Re NATIONAL CERAMIC INDUSTRIES. – Expansion at Rutherford.

I wish to pass comment re the above document MP 09-006-Proposed Expansion of Ceramic Tile Manufacturing Facility (National Ceramic Industries Australia-NCIA), 175 Racecourse Road, Rutherford, N.S.W.

VISUAL ASSESSMENT VIEWING LOCATIONS AND
AIR QUALITY RECEPTORS

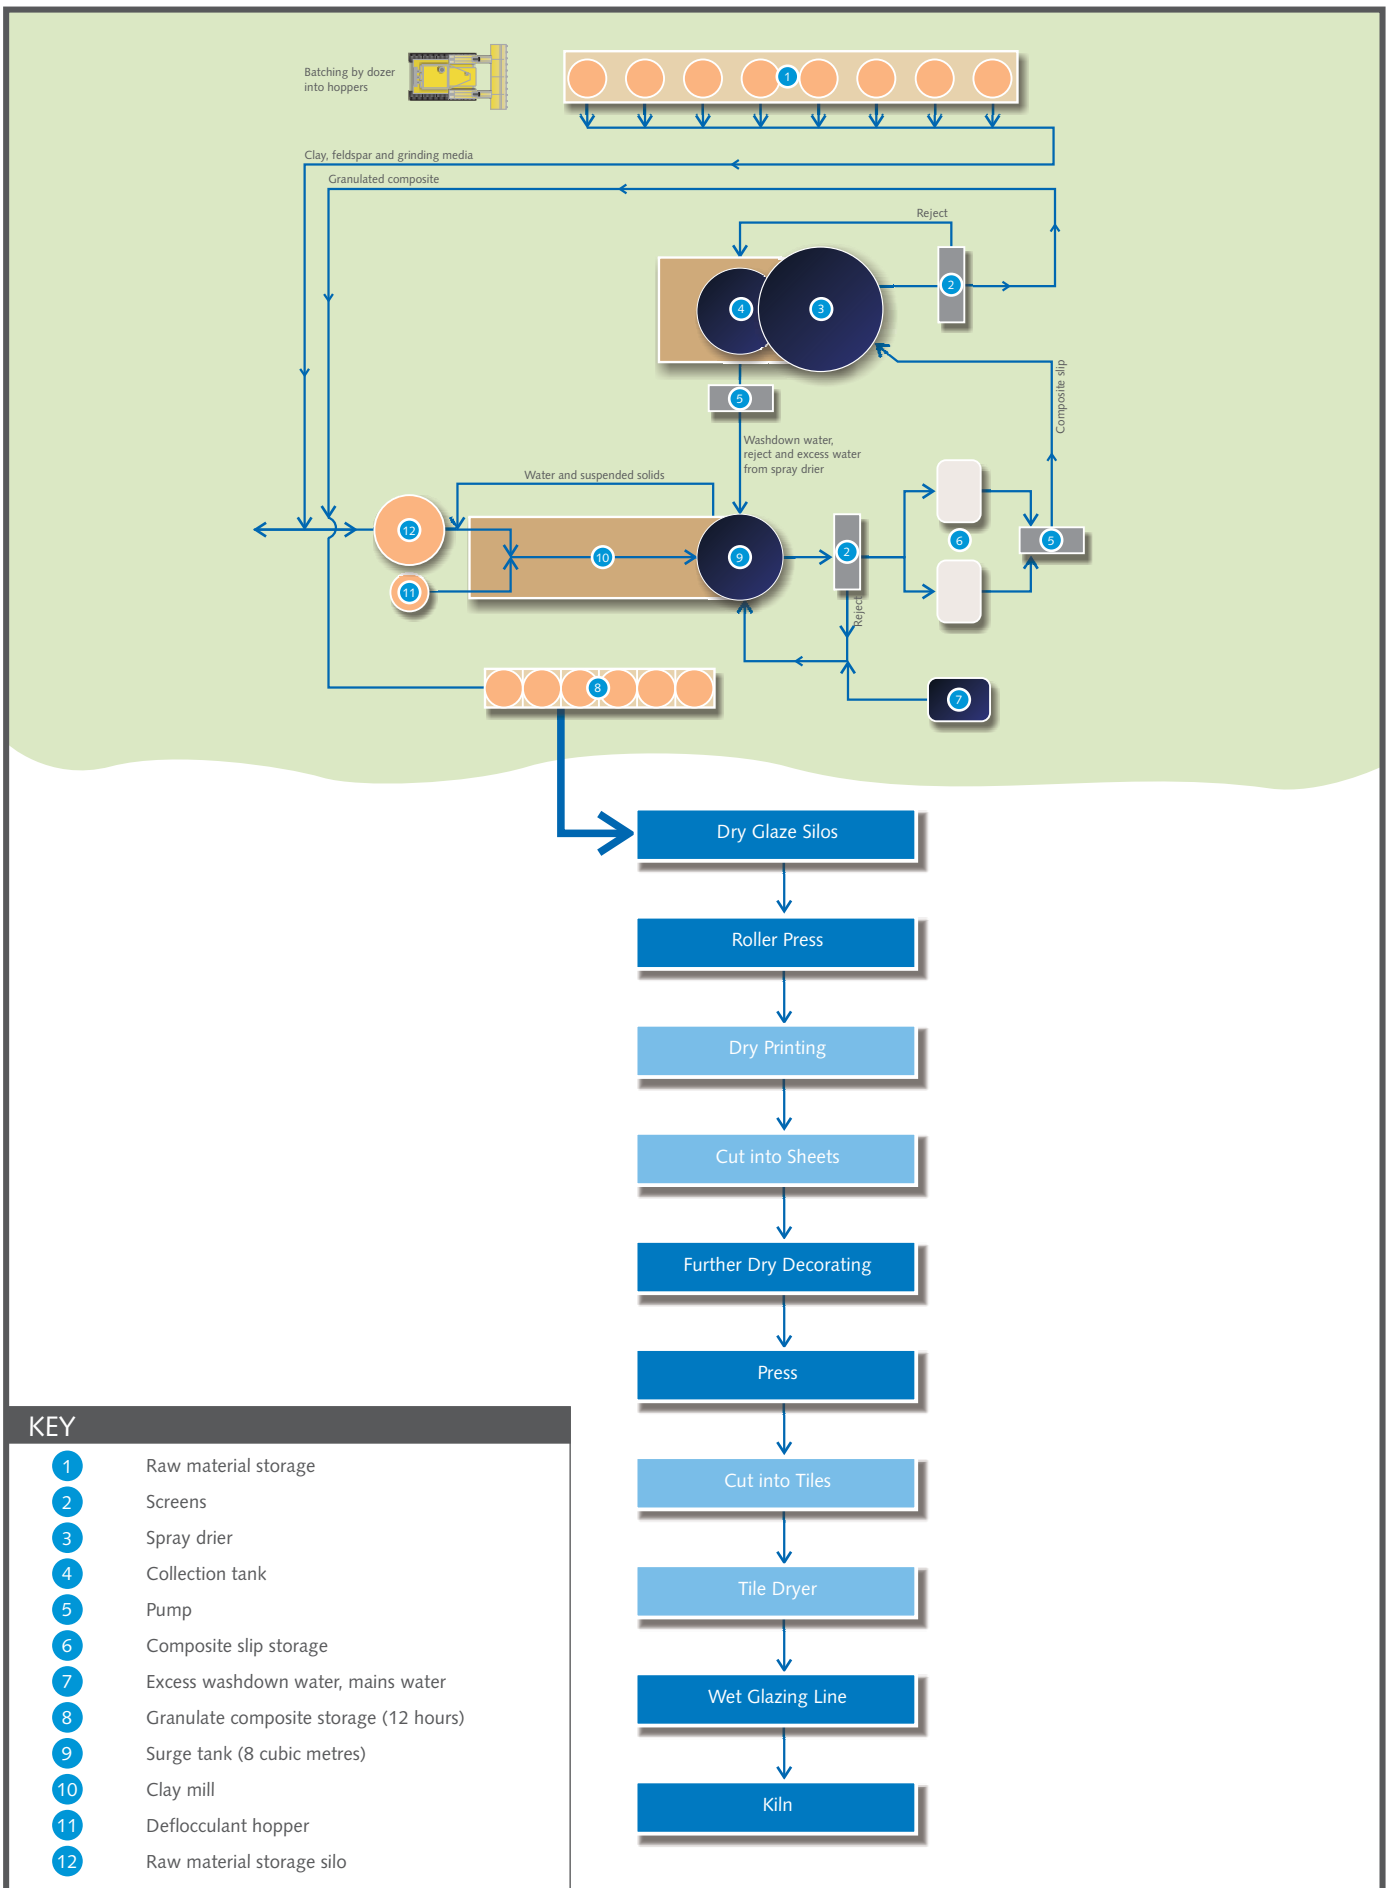
This grape vine is located approximately 4.8 kilometres from the tile manufacturing plant in a westerly direction and approximately 500 metres due west of existing Air Quality Receptor 12

We have no idea of what any measureable levels of fluoride may have been in the past six or so years simply because there is no Air Quality Receptor data available for our location. Taking data from elsewhere and relating that data to our property will only produce “useless results” due to our many years of observations of physical atmospheric pollution results from stratified air flows across the flat area to the east of our property and west of the National Ceramics site.

The existence of air quality receptors and or any emission measuring program, operating from the start of production in Stage 1 of this facility was never made known to the general public. Secondly had those responsible for the location of the air quality receptors made inquiries of local residents, the writer and other residents could have provided them with information collected over 40 years of the effects of atmospheric pollution upon plants, both annual and perennial, as well as significant deterioration of gutters and fencing wire. We could have also indicated areas where air quality receptors have been installed, the actual results of which could have been predicted from experience, and are now a waste of time and resources.

This information reveals that actual output of any Fluoride compound can only be measured at four discharge points, being from the factory itself. This information clearly indicates that there is not available any information in relation to the actual measurement at any time of fluoride containing compounds at any of the air quality receptor measuring sites NOs 1-13 and 18-21 inclusive.

There is no base data for these various sensitive receptors being number1 to13 inclusive and 18 to 21 inclusive, at any stage during the period of operation to one of two production lines.
